Subject: Planning Application EP/23/19/HH

Please see below my responses to Mr Haynes comments shown in his email of 1st April 2019. The numbering is that used in his email for sake of clarity.

41 Sea Lane, East Preston BN16 1NE

Proposed Car/Caravan port
 43, Sea Lane , East Preston
 BN16 1NE
 Sheet 1
 Dimensions in mm
 Date- 19th February 2019
 Drawn- Paul Haymes

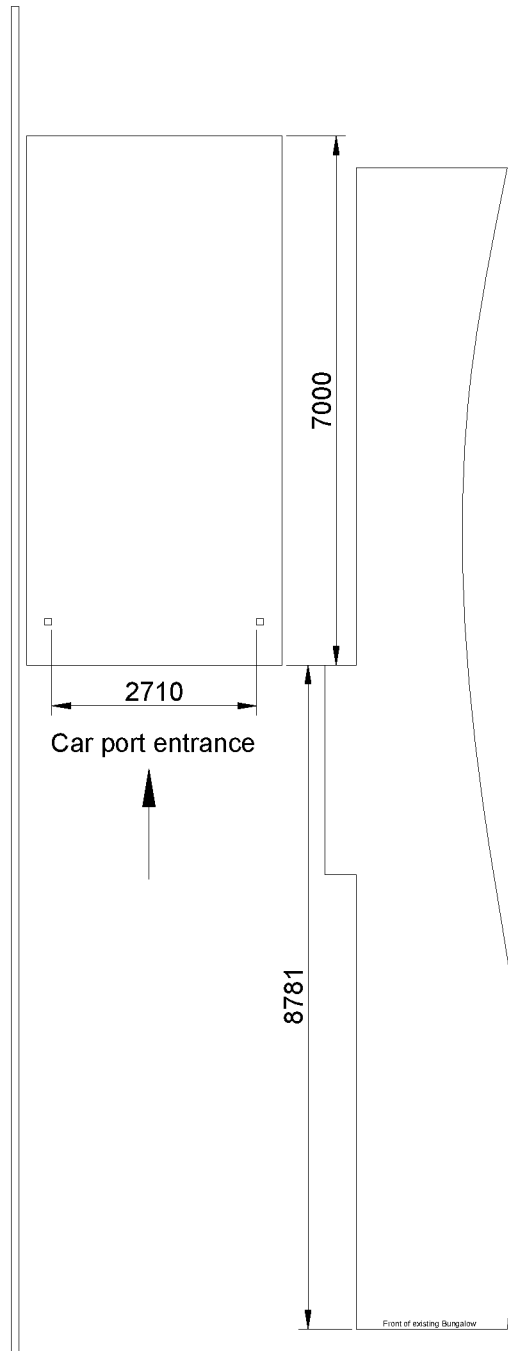
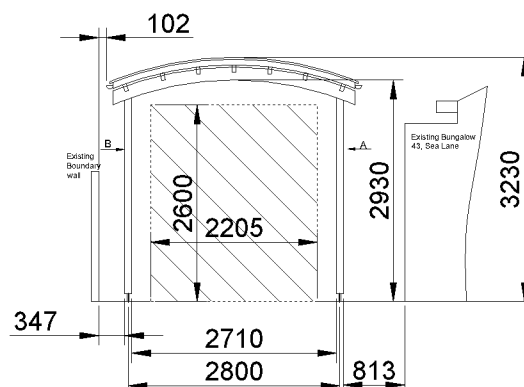
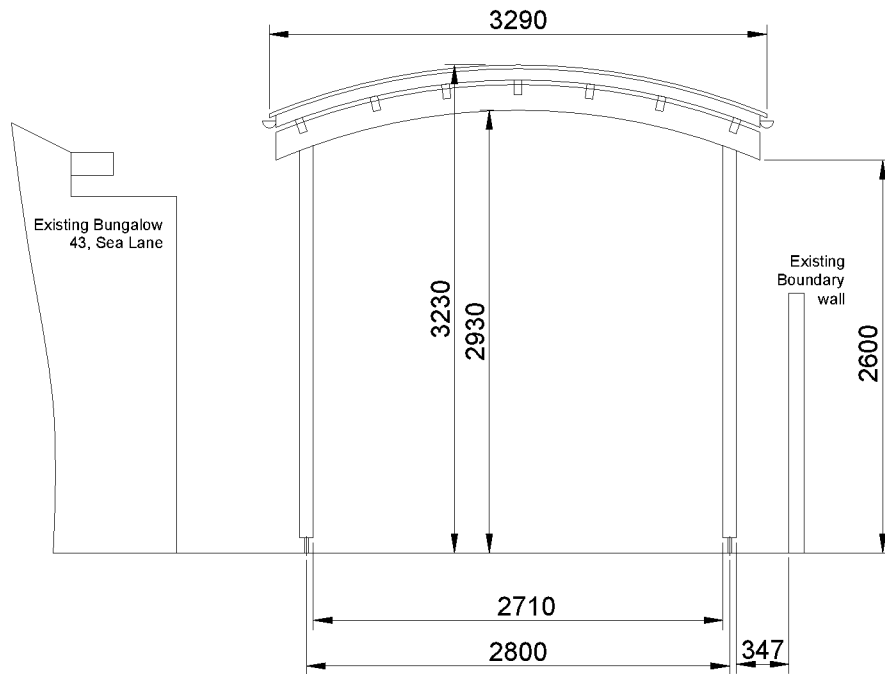
6 - The posts being moved is noted but still very close to the wall. With regard to our trellising this was erected in place of bushes and trellising put in place by the original owner against the wall. I'm not aware whether he had done this to block out the sight of the caravan. When we were erecting the trellising Mr Haynes said in friendly manner that he expected we were doing this to hide the sight of his caravan. I did not disagree with him.

Proposed Car/Caravan port
 43, Sea Lane , East Preston
 BN16 1NE
 Sheet 2
 Dimensions in mm
 Date- 19th February
 Drawn- Paul Haymes

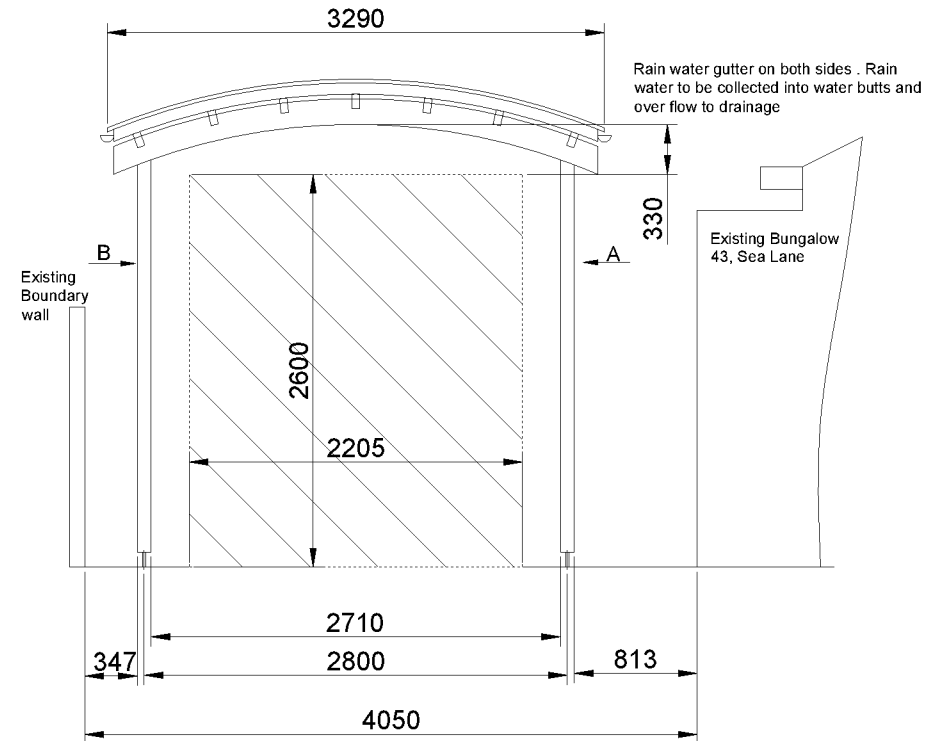
10- The height of the proposed structure will affect the sunlight. On a recent sunny afternoon I climbed a ladder, next to the wall, to around the same height of proposed structure and my body threw a shadow over nearly 2/3rds of our patio area. The caravan stored in 43 Sea Lane is higher than the trellising in my garden and higher than any of the shrubs mentioned. There is only one tree which is at the furthest point away from the our patio and this doesn't affect our sunlight.
